## NSW RURAL FIRE SERVICE

Our reference: DA20221111011703-Original-1

### Other - Other Assessment - Educational Establishment

**Gregory Hills Primary School 28 Wallarah Circuit Gregory Hills NSW 2557, 3257//DP1243285**

Figure 41 Proposed APZ (source Blackash)

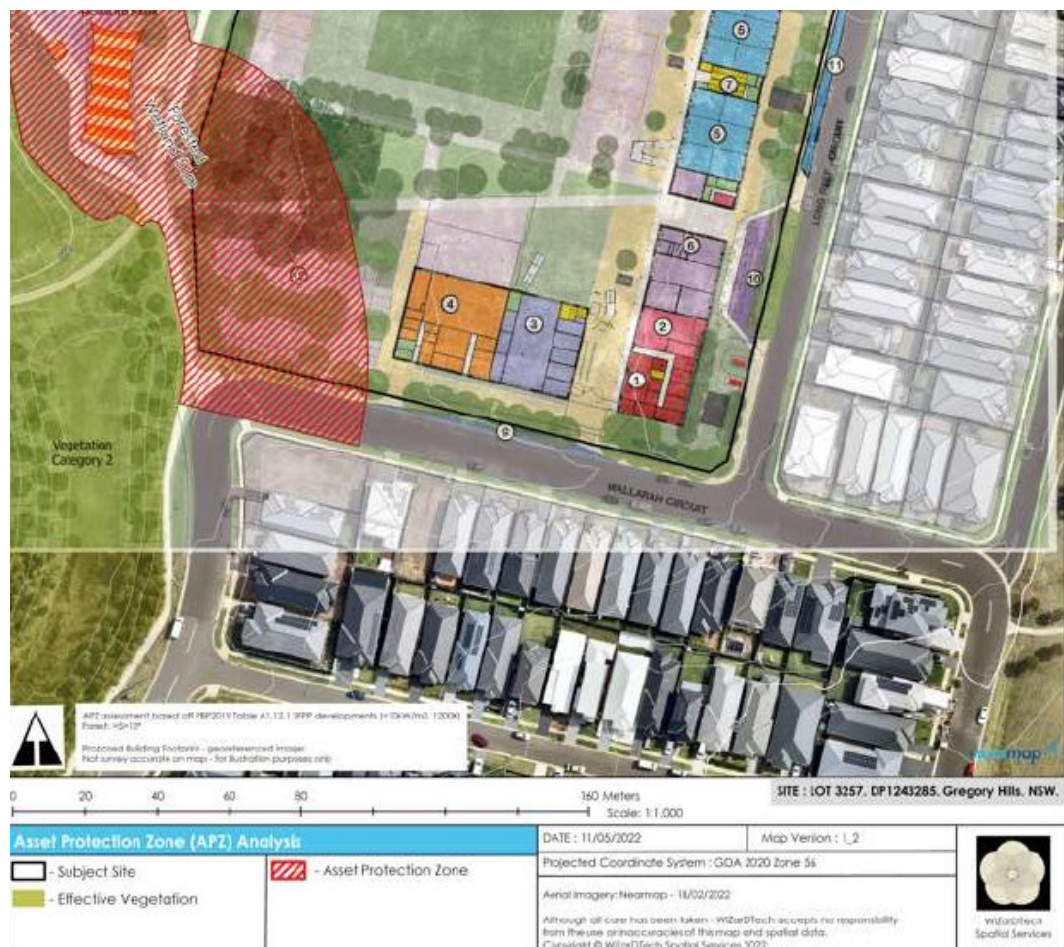
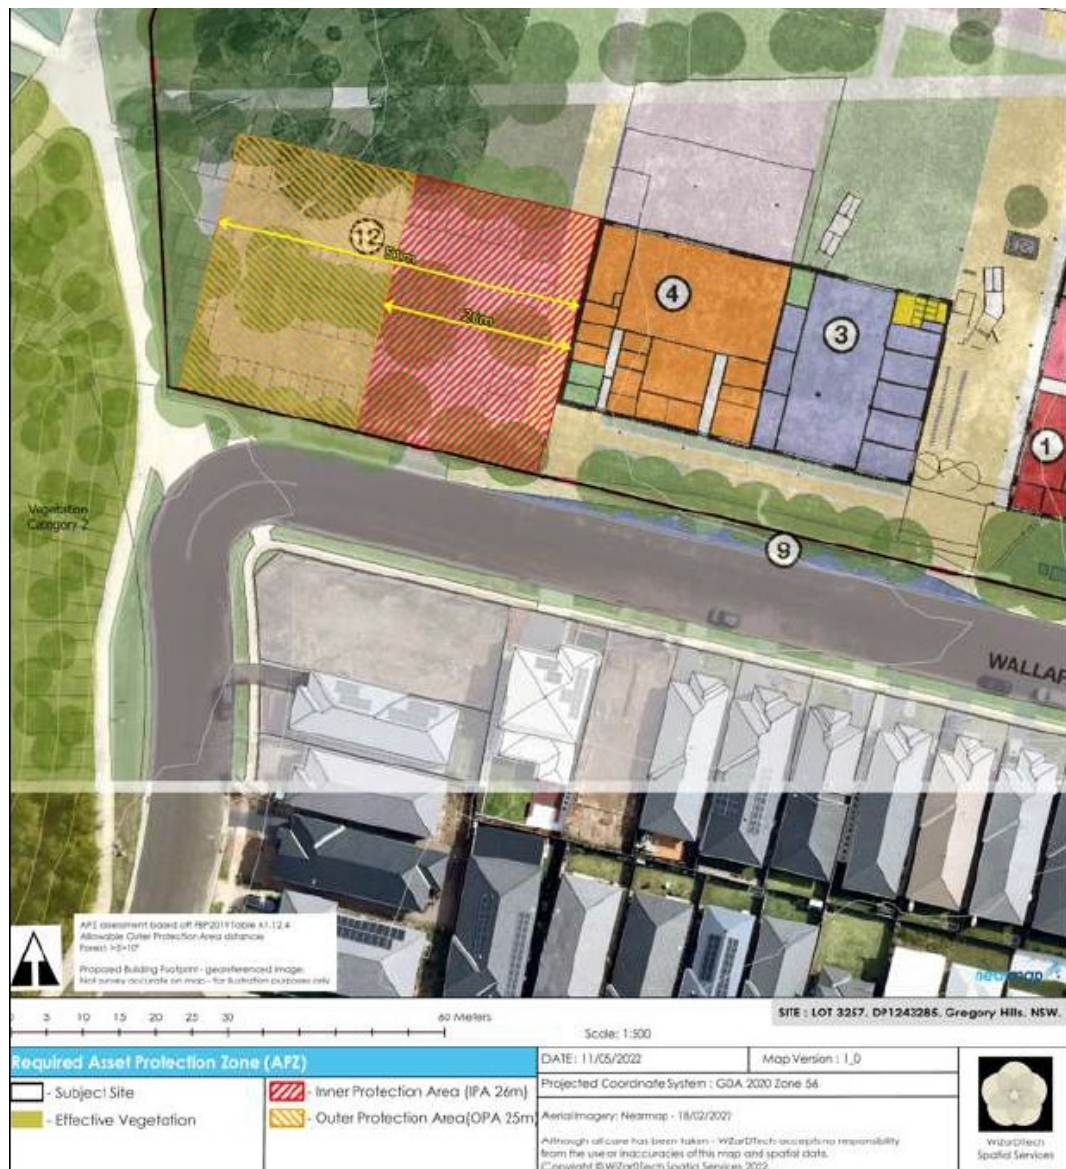
1. From the start of building works, and in perpetuity to ensure ongoing protection from the impact of bush fires, the property around the proposed school buildings on the western aspect must be managed as shown in Figure 12 of the Bush Fire Report (Ref: J2809, Version 1.7, dated 28 October 2022, prepared by BlackAsh Bush fire Consulting):

- An inner protection area (IPA) for a distance of 26 metres; and,
- An outer protection area (OPA) for a further distance of 25 metres.
